CITY OF ALBUQUERQUE

RE: **13424 Cedarbrook Ave NE**
Grading and Drainage Plan
Engineer's Stamp Date: 9/24/18
Drainage File: F23D013

Based on the submittal received on 9/24/18, the grading and drainage plan cannot be approved until the following are corrected and a complete resubmittal is made:

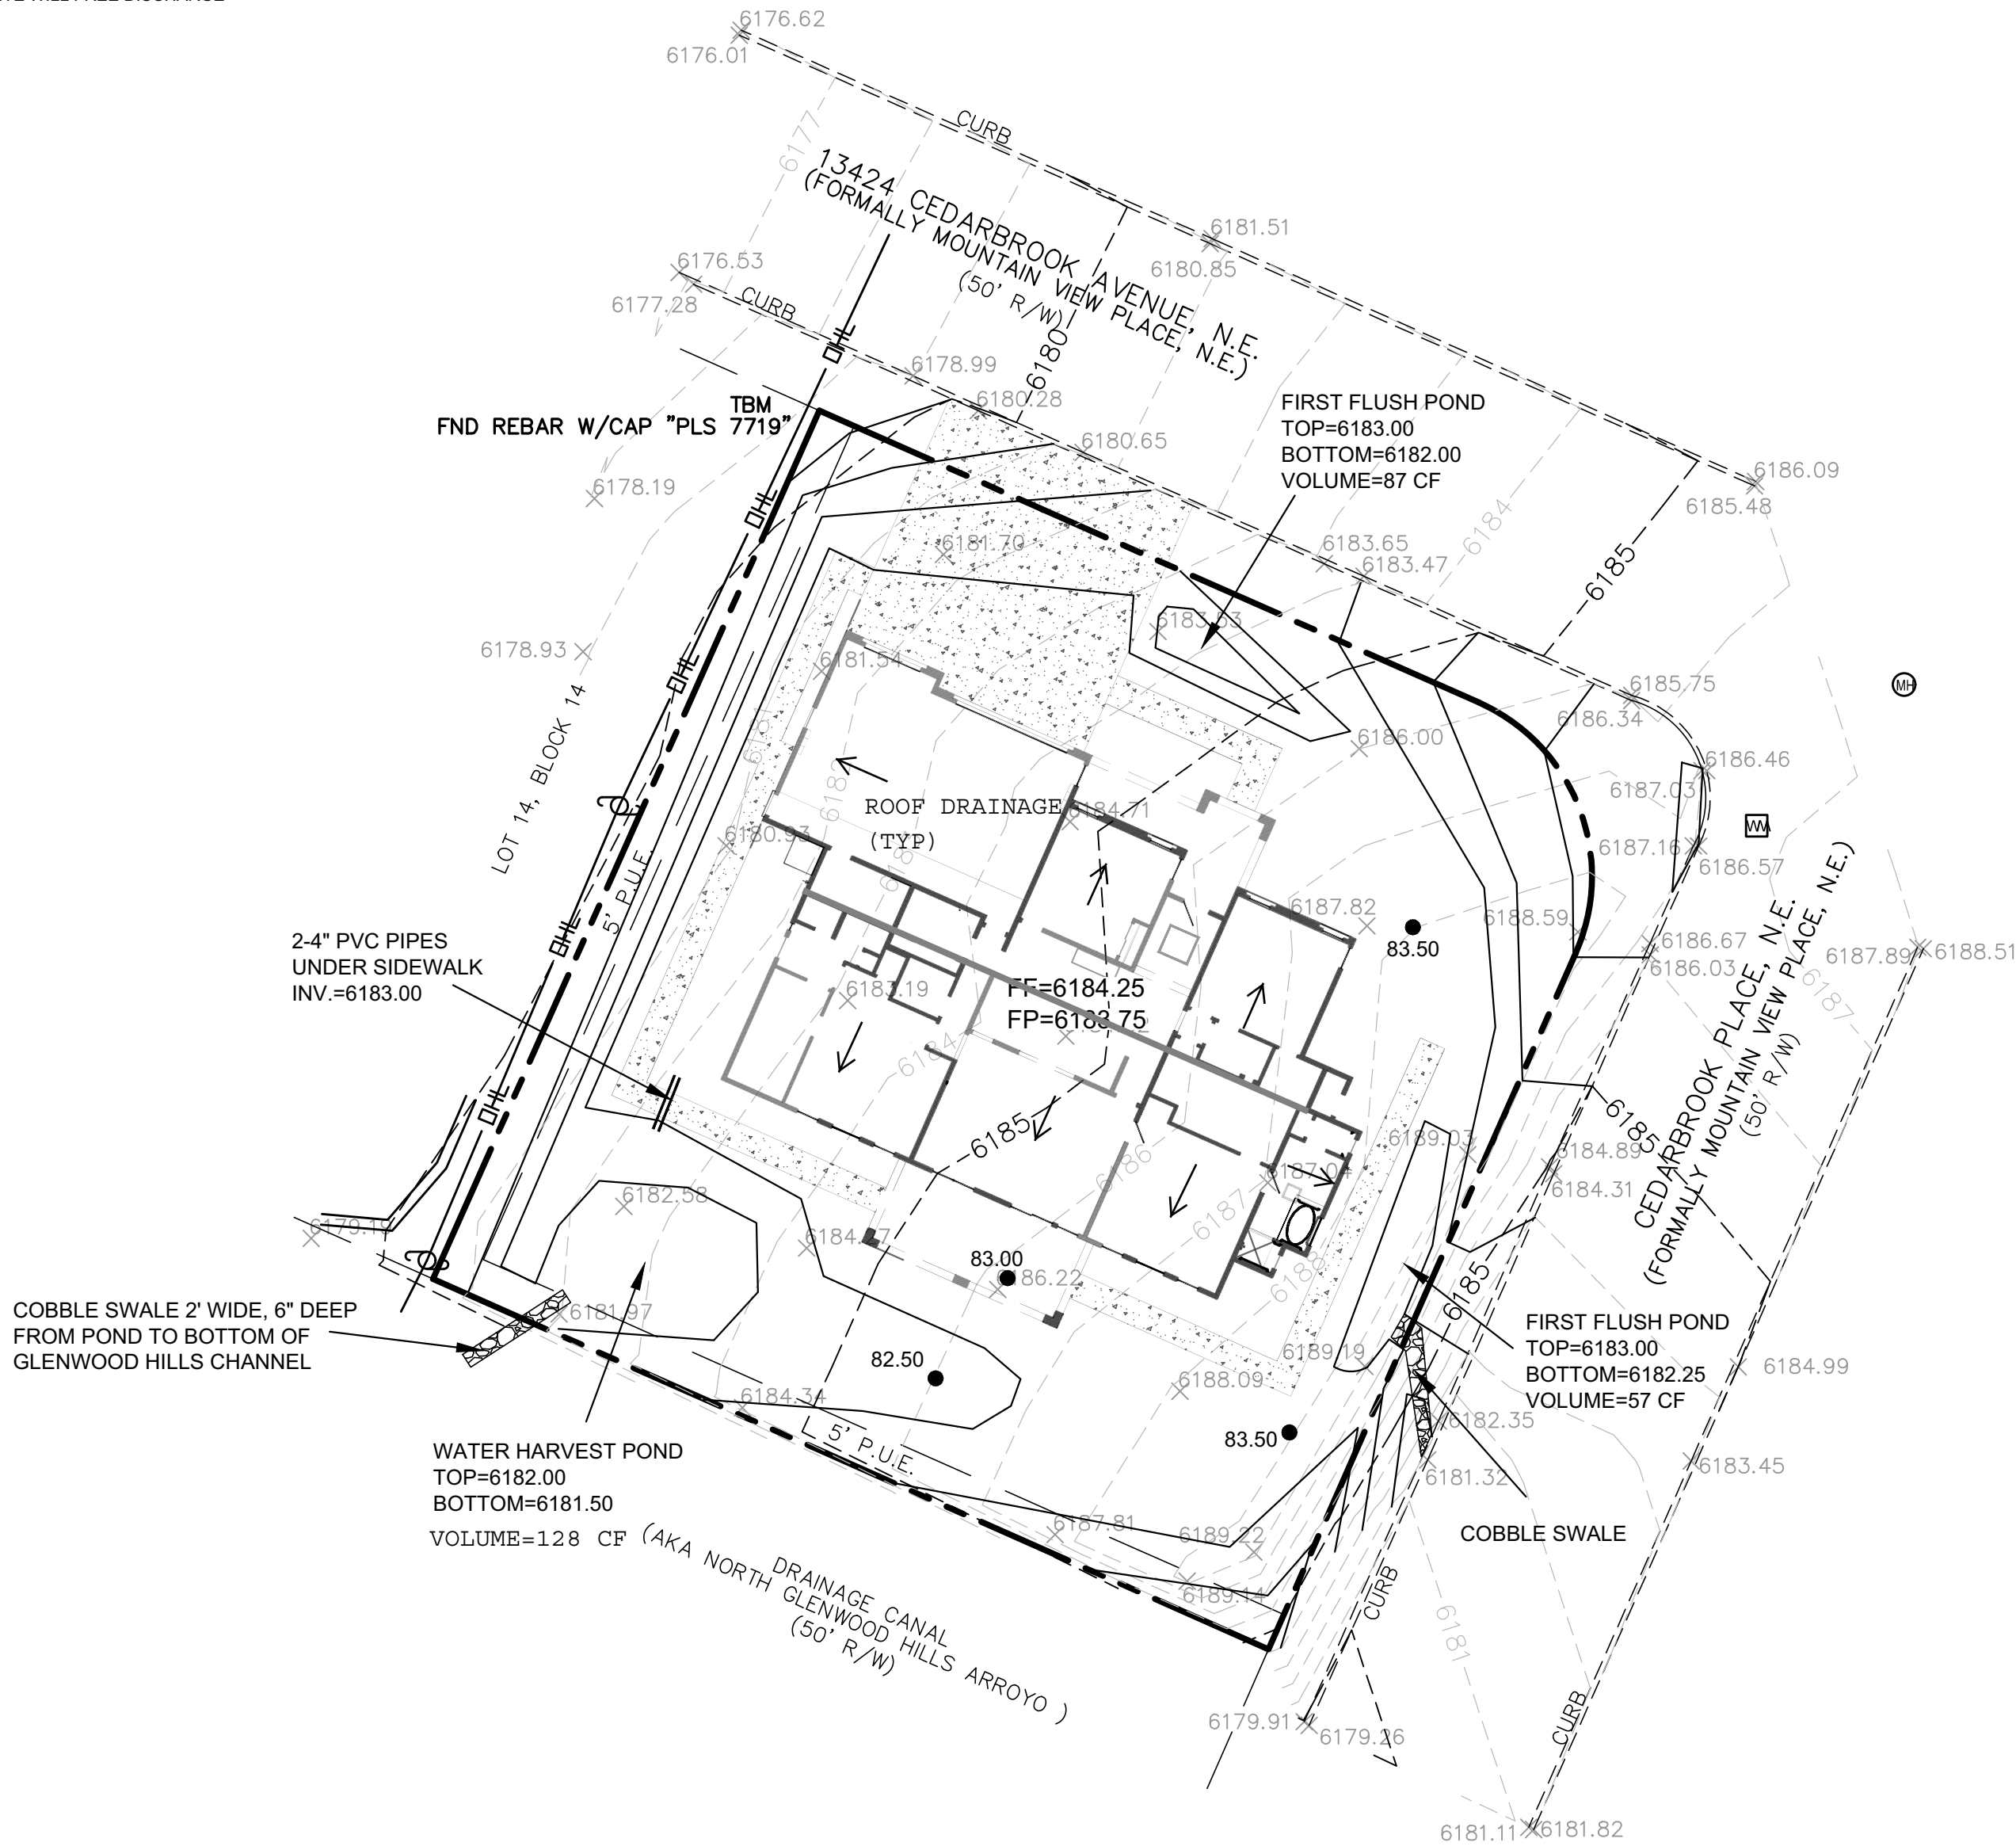
1. Show the adjacent grades in N Glenwood Hills Arroyo; ensure that your grading ties-in at the ROW line. Do not lower the grade adjacent to the arroyo.
2. Label the proposed contours.
3. First flush is not required on single residences; the ponds may be removed if desired.
4. Because N Glenwood Hills Arroyo is an unnumbered A-zone; make a reasonable assumption as to the 100-yr water surface elevation at the upstream edge of this lot and ensure the pad is elevated above it (+1ft freeboard recommended).
5. Do not regrade the ROW along Cedarbrook Place; it's keeping the water in the arroyo.
